Submission No.			276	
Organisation Name or Name of Submitter			Save Markievicz Pool & Gym Campaign	
Item No.	Section Ref.	Page No.	Observation Statement	TII Response
Railway (MetroLink - Estuary to Charlemont via Dublin Airport) Order [2022] Case reference: NA29N.314724				
1	Introduction	1	Whilst we very much welcome the overall MetroLink project for the improvements it will bring to the public transport network in and around Dublin, we feel that aspects of the Draft Railway Order contravene Government housing policy; the proper social and economic planning and sustainable development of the area affected by the Tara Station; and are economically reckless.	<p>TII wish to thank you for your submission and stated support for the delivery of MetroLink. The delivery of MetroLink has been assessed against all relevant planning policy at a European, national, regional and local level, as presented in the Planning Report which accompanies the EIAR.</p> <p>The consideration of alternatives to the project date back to the North Fingal Transport Study in 2015, and since then have iterated through the NTA's GDA Transport Strategy 2016-20235, the Emerging Preferred Route Report (2018), the Pr

TARA STATION

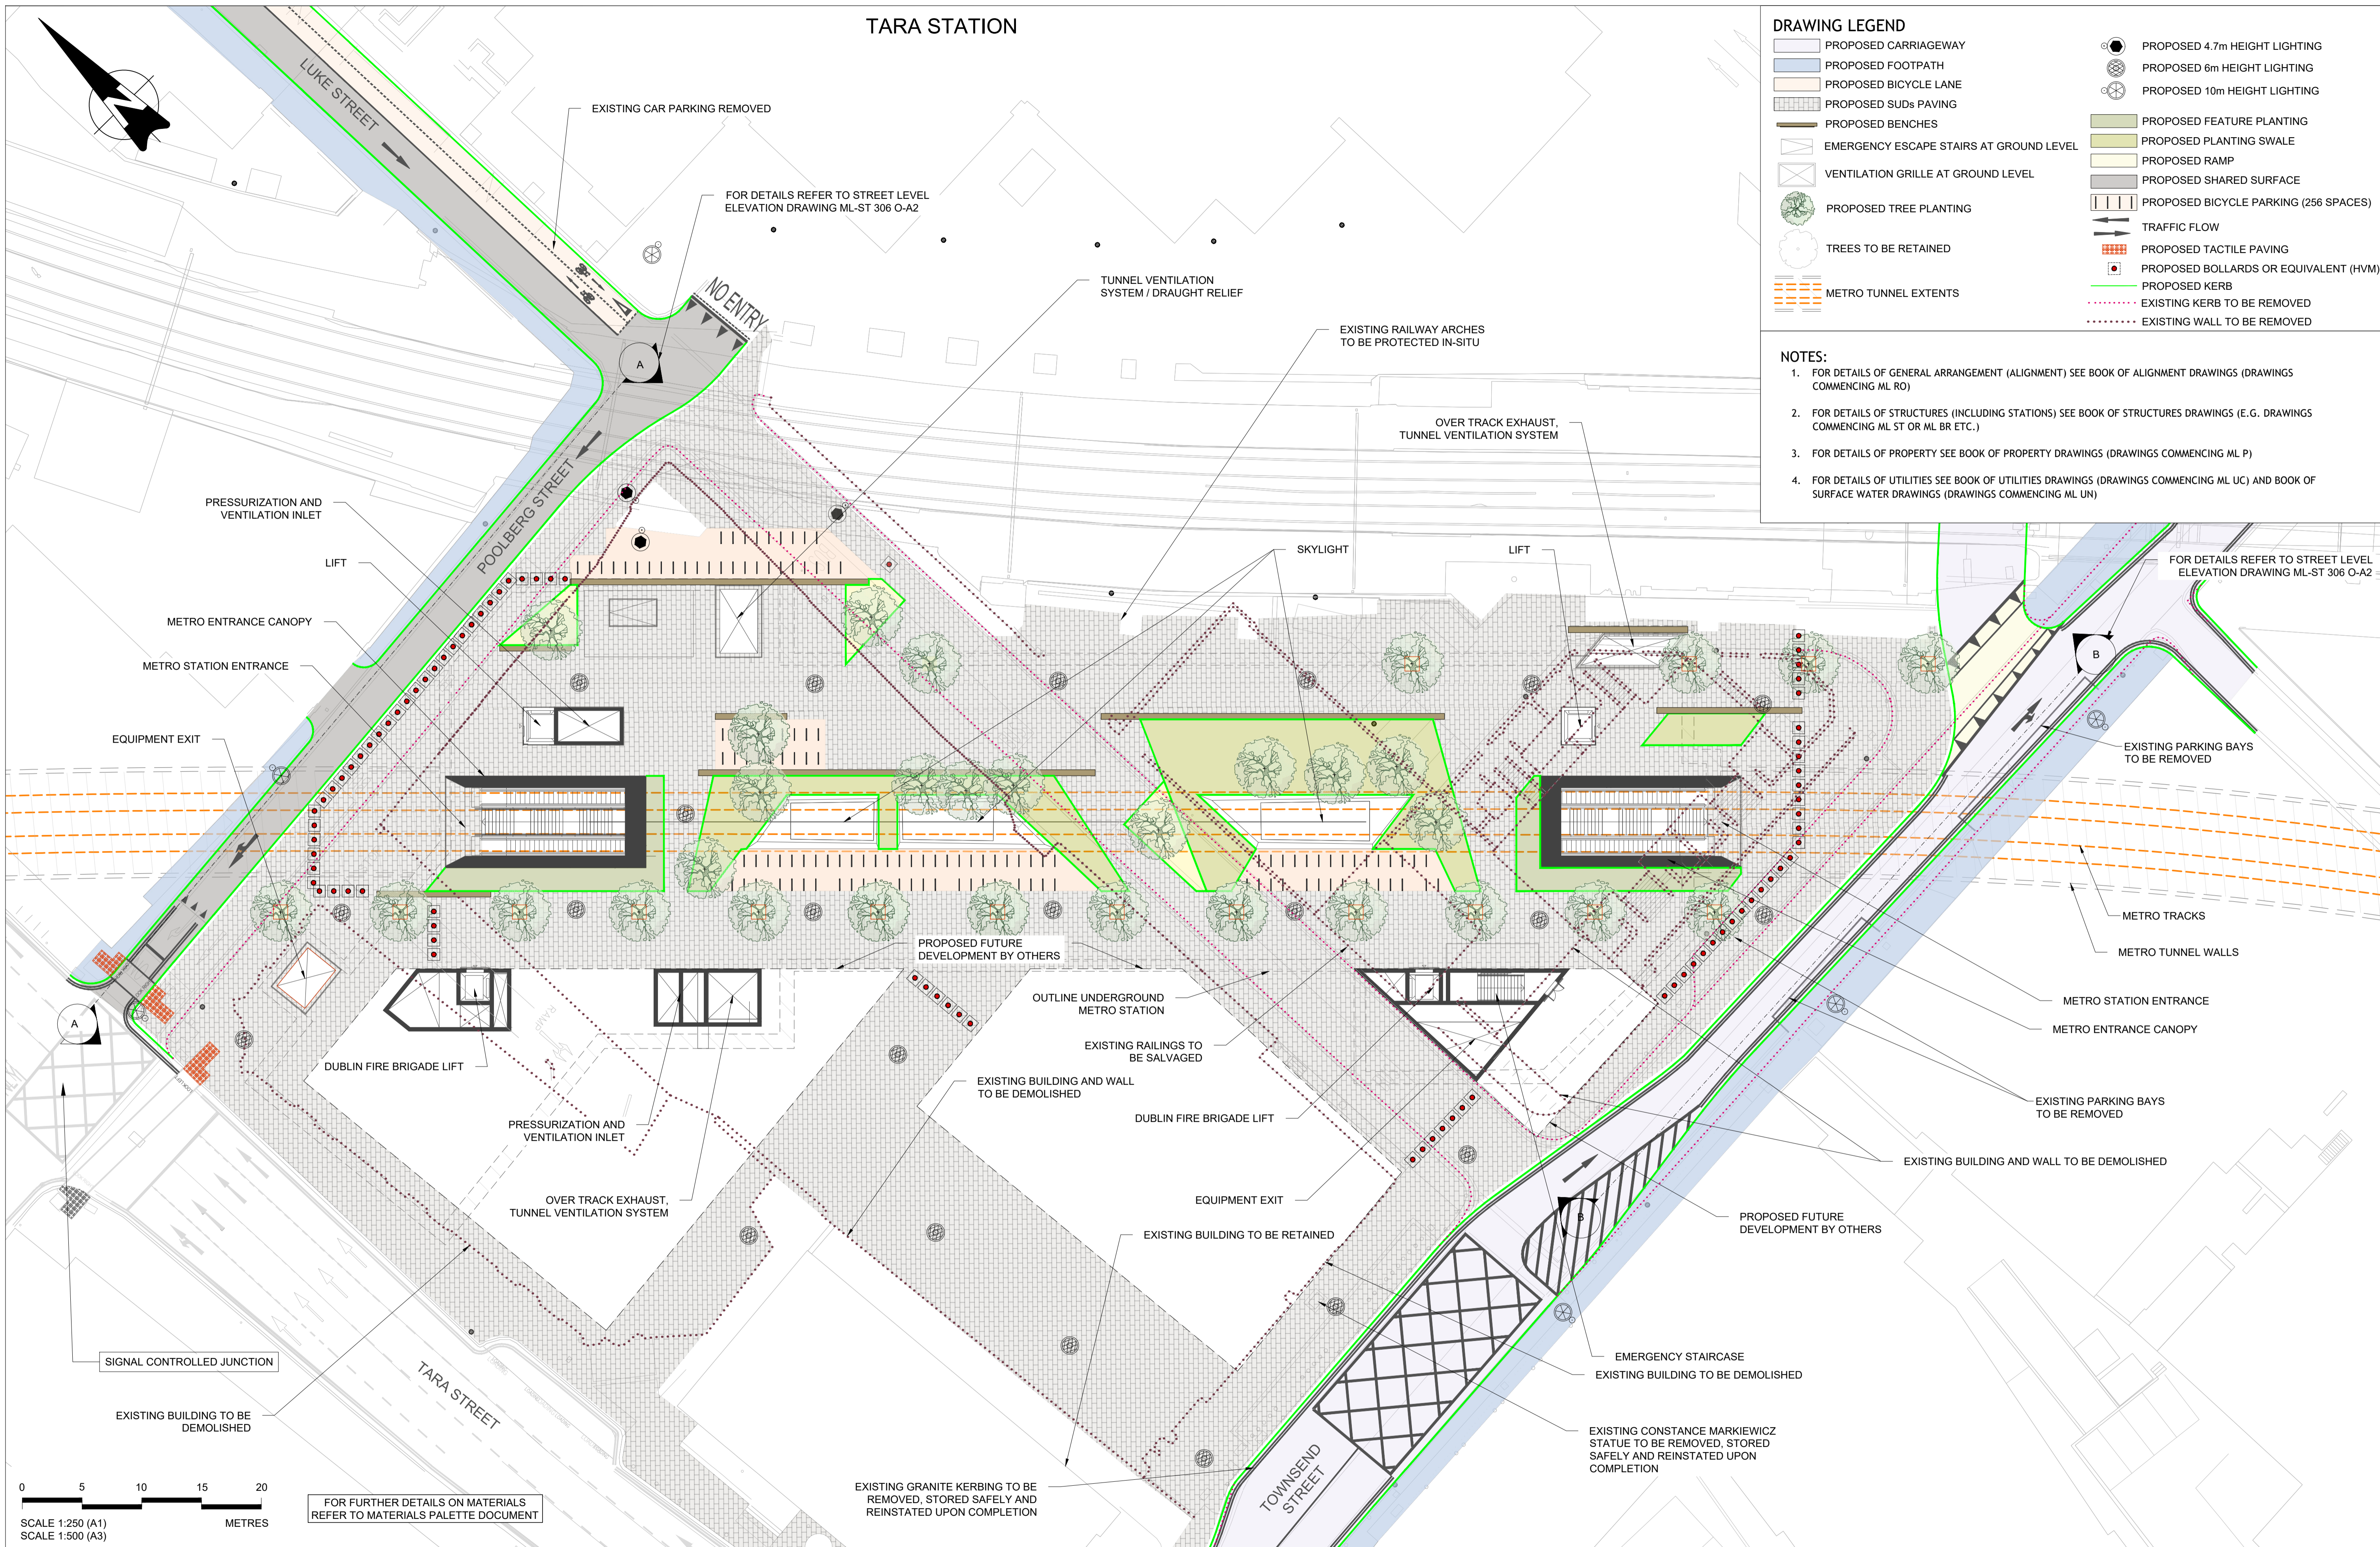
2	Impact on community	1	Tara Station as it is proposed will have the most negative impact of any of the stations on affected communities along the metro line, with 78 relatively recently constructed, good quality homes to be destroyed. College Gate, comprising 70 apartments and 8 duplexes on Townsend Street owned by Dublin City Council and housing mostly elderly tenants, many of whom have lived in the area all their lives, as well as the Markievicz Leisure Centre, which has the only large public swimming pool in the city centre, and a gym.	<p>As a result of the selection of the preferred option for reasons noted in response (5) below, mitigation for the loss of the College Gate apartments is being addressed as part of the Project with the support of DCC.</p> <p>TII will continue to work with DCC in relation to the development of an alternative sports and recreational facility to replace the Markievicz leisure centre and intends to fund the alternative. However, TII does not have control over that development, which is part of DCC’s function to provide public sport and recreational facilities in its function area. DCC may or may not be in a position to deliver it in parallel with the MetroLink project. Accordingly, the Board should assess the MetroLink project on the basis that the alternative may not be available. The impact would then be significant, but nonetheless one that would not outweigh the strategic scale long term benefits that MetroLink will deliver.</p>

8	Lack of due consideration given to alternative proposals	3	<p>A) Option 1 (under Hawkins House/Apollo House site) was proposed because, in addition to avoiding the demolition of the College Gate/Markiewicz Pool building and the 8 homes on Townsend Street, it would reduce the journey time as a station there would create a gentler curve along the Metrolink line compared to the original proposal on Luke Street. Also, this more straightforward route would require 125m less tunnelling. In the Jacobs Idom Report/Appendix M (above) this is dismissed as not viable because it would require "a complete re-alignment of the tunnel approaches ... incompatible with TBM tunnel construction".</p> <p>However, each tunnel boring machine (TBM) is custom built for the job. Tunnelling under existing structures — big or small — is how subways are built in cities all over the world. Modern tunnel boring machines adapt to all kinds of underground conditions, like densely packed soil, rock or areas with high water pressure. And when the Metrolink project was launched in September 2015, reducing the amount of tunnelling involved from that planned under the previous Metro North project, was described by then Minister for Transport, Paschal Donohoe, as the main contributory factor in vital savings of approximately €1bn.</p>	Please refer to response (5) above in relation to the several options assessed as part of the decision-making process at Tara Street. Further details on the assessment can be found in Appendix A7.2 Tara Street Report (appendix to Chapter 07 Consideration of Alternatives) of the EIAR. Option 1 (under the Hawkins Development) would require realignments of the tunnel section between O'Connell Street Station and Tara, with curve radii reduced significantly below desirable design standards required for MetroLink operation (see Appendix A7.2 section 3.4.1). As such, this option was not considered viable.
